# Rezoning Transportation Analysis

Petition Number: 2023-176

**From: Jake Carpenter, PE**

Date	Description
01-23-24	First Review (IW)
02-21-24	Second Review (IW)

SITE DEVELOPMENT DATA - COMPREHENSIVE TRANSPORTATION REVIEW SUMMARY

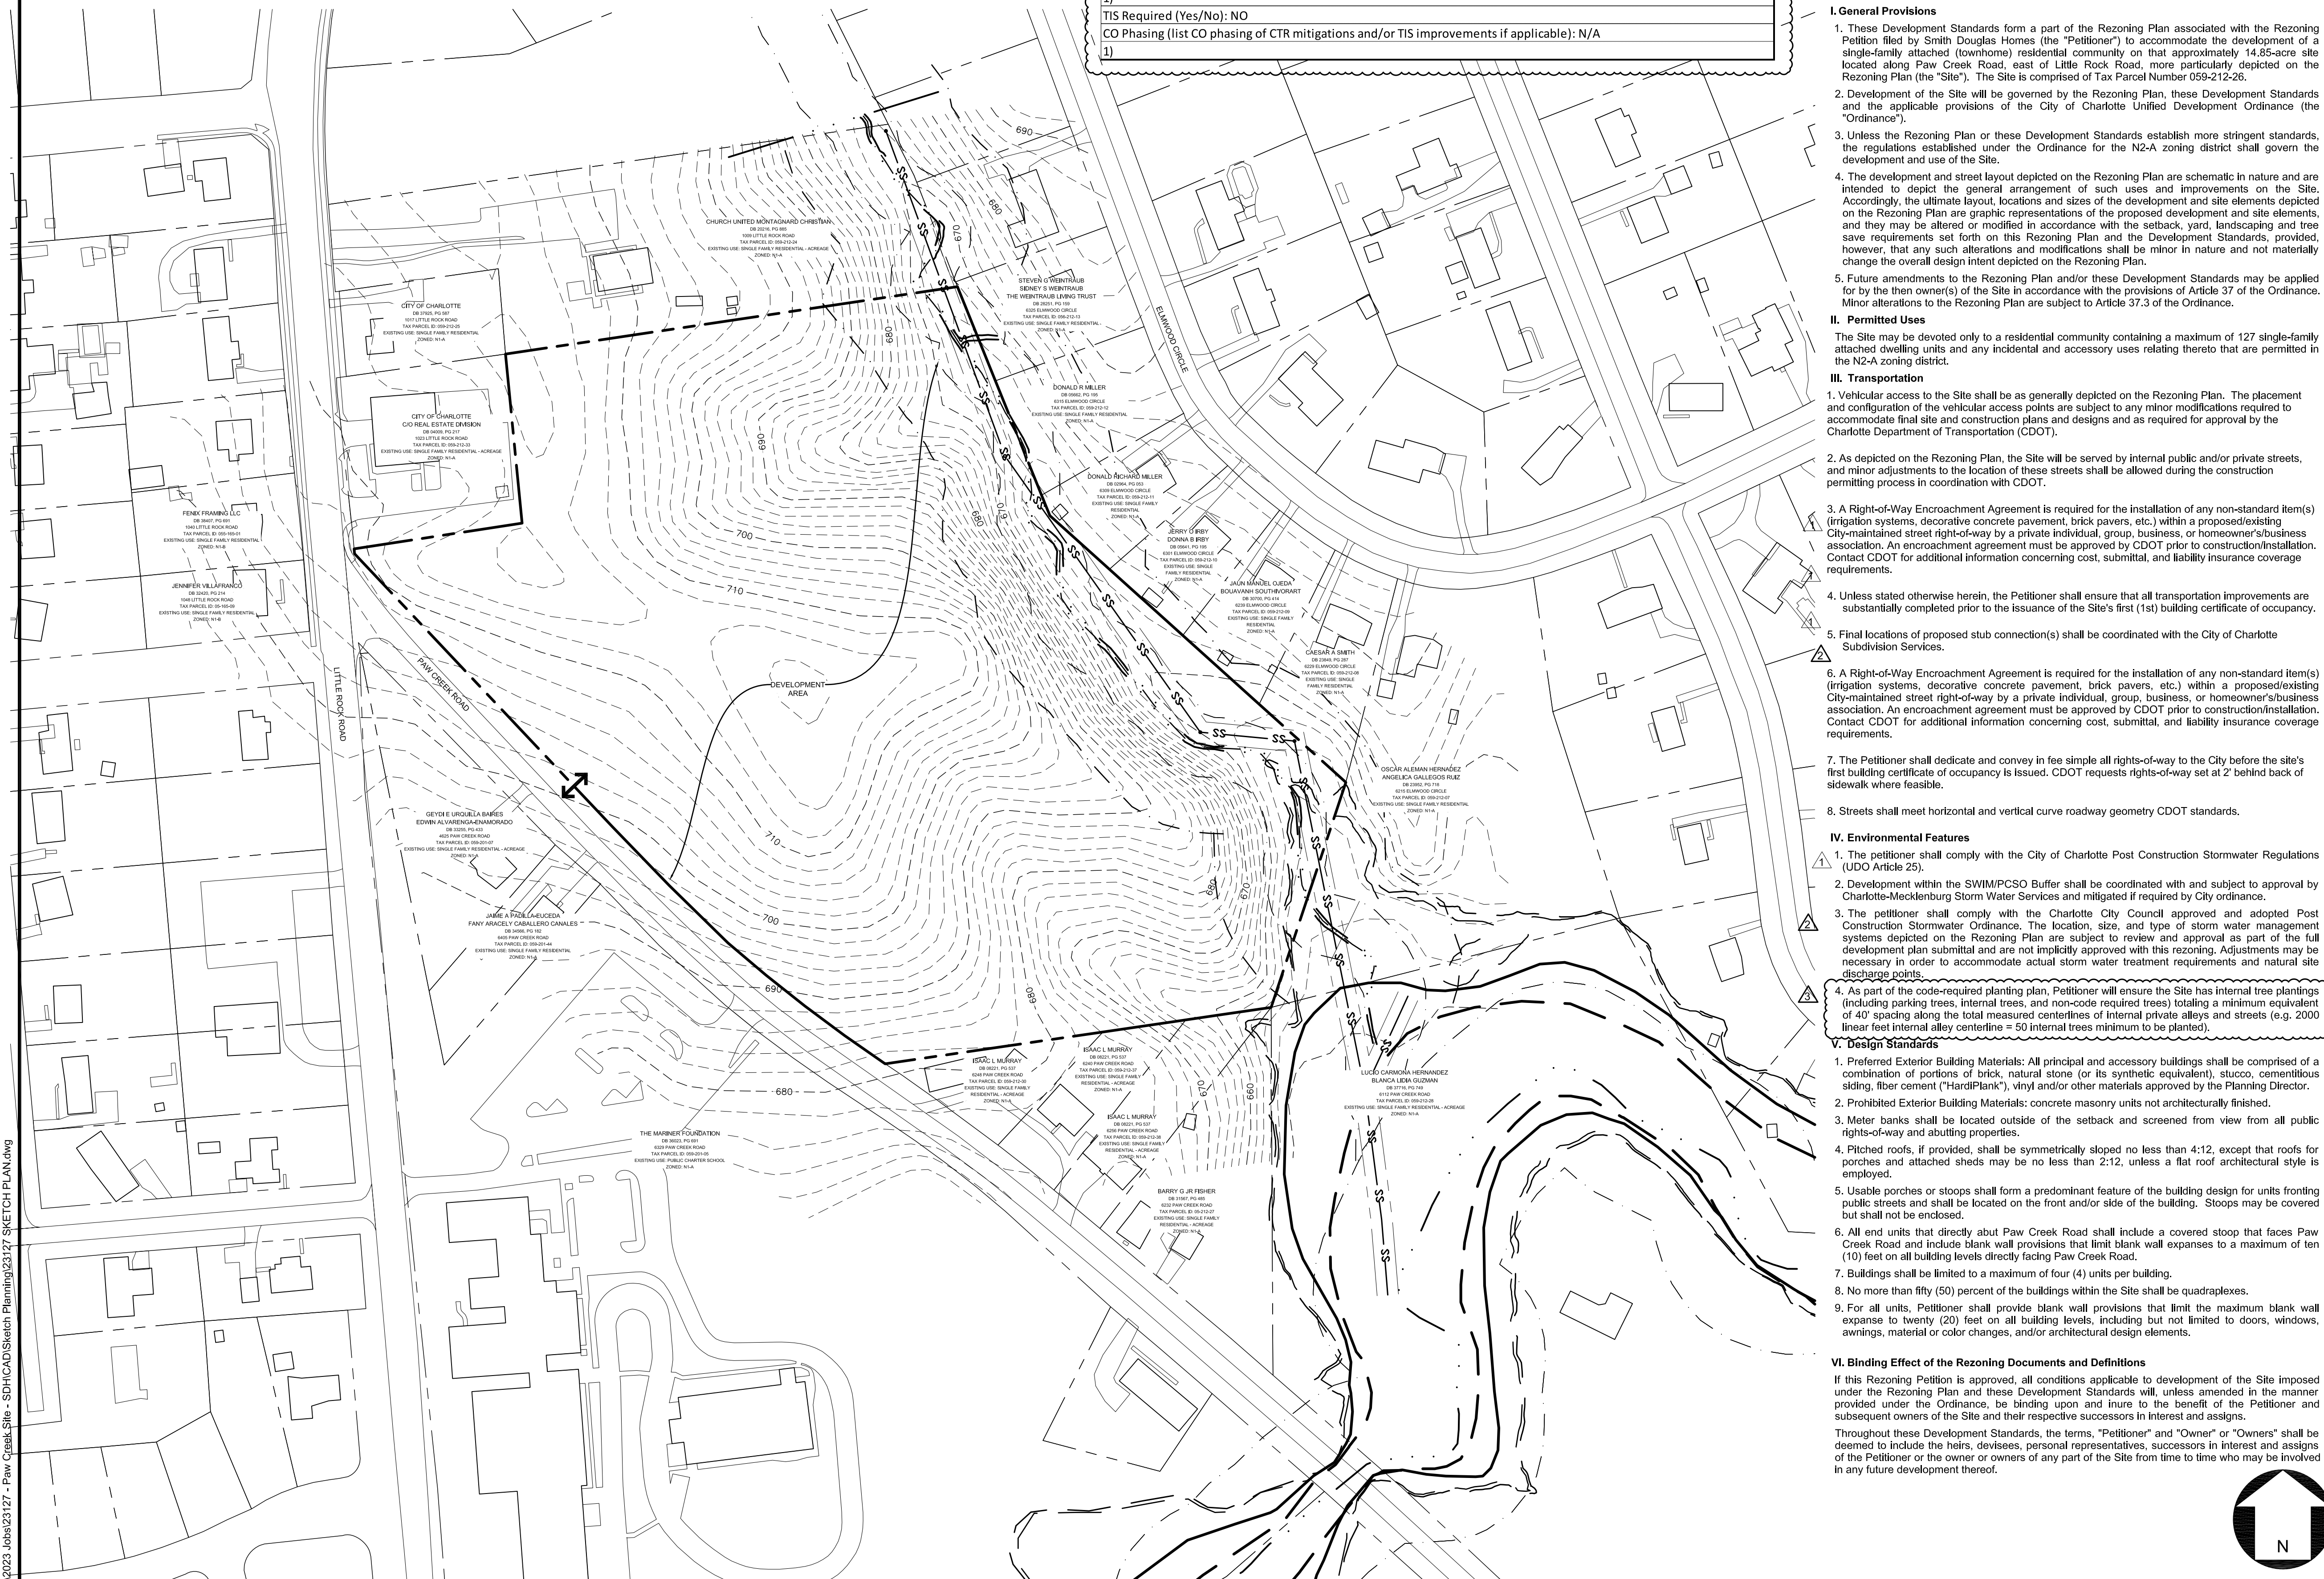
**Clarifying comment 02.21.24:** See Table 3.3 Multimodal Assessment Mitigation Options in the Charlotte Streets Manual for guidance. Complete CTR summary table and include on the revised plan. CTR table link (use Site Data Table – CTR Summary tab): <https://www.charlottenc.gov/files/sharedassets/city/v/2/growth-and-development/documents/dev-center-fees/resources/udo-site-data-tables-curb-ramps-and-ctr.xlsx>
